Warragamba Dam wall raisin
SSI – 8441
Submission

Chapter 15 Flooding and Hydrology

15.4.1 Historical flooding in the Hawkesbury-Nepean Valley

Figure 1 – Relative contribution of river catchments in the Valley (Figure 2 in EIS)

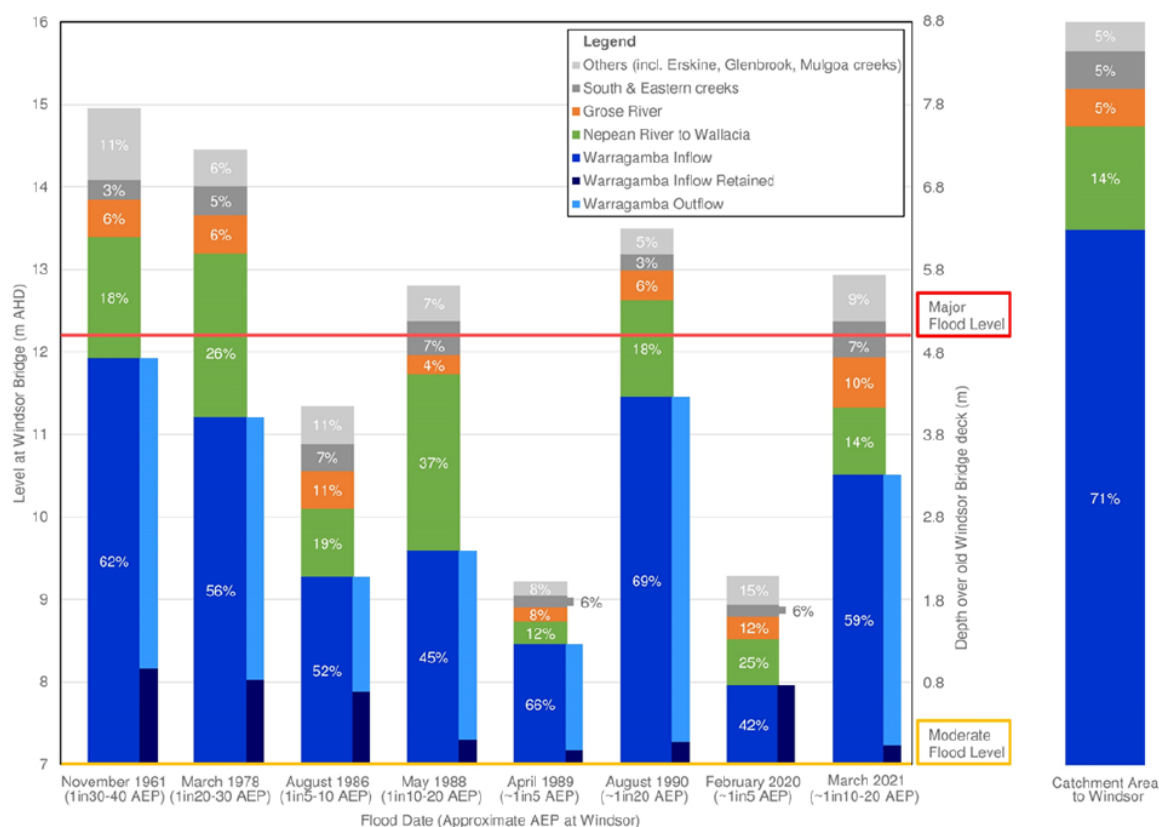
Gives examples on a graph of flood events with water coming from: Warragamba, Nepean, Grose, South Creek and others for years 1961; 1975; 1986 7 1990.

Note: the August 1986 flood event was smaller than a 1 in 20 chance per year flood, with Warragamba Dam contributing only 42% of the total volume at Windsor. This is because Warragamba Dam storage level was relatively low and captured a large portion of the incoming flows thus delaying the downstream flows. If Warragamba Dam had been full, the Warragamba Catchment would have contributed 57% of the volume at Windsor.

The above statement is bias as it does not mention that the Upper Nepean Dams, Cataract, Cordeaux, Avon, and Nepean Dams were also low at the time and had to fill before spilling into the Nepean River system.

Perhaps another new extended graph including earlier and later floods such as the: June 1867; February 1873; February 1898; June 1949; February 1956; June 1964; November 1969; March 1977; March 2022 & July 2022, may get a better unbiased result?

In any event after Warragamba Dam being built should include the storage level of the Upper Nepean Dams to exclude a bias of all part full dams at the same time.
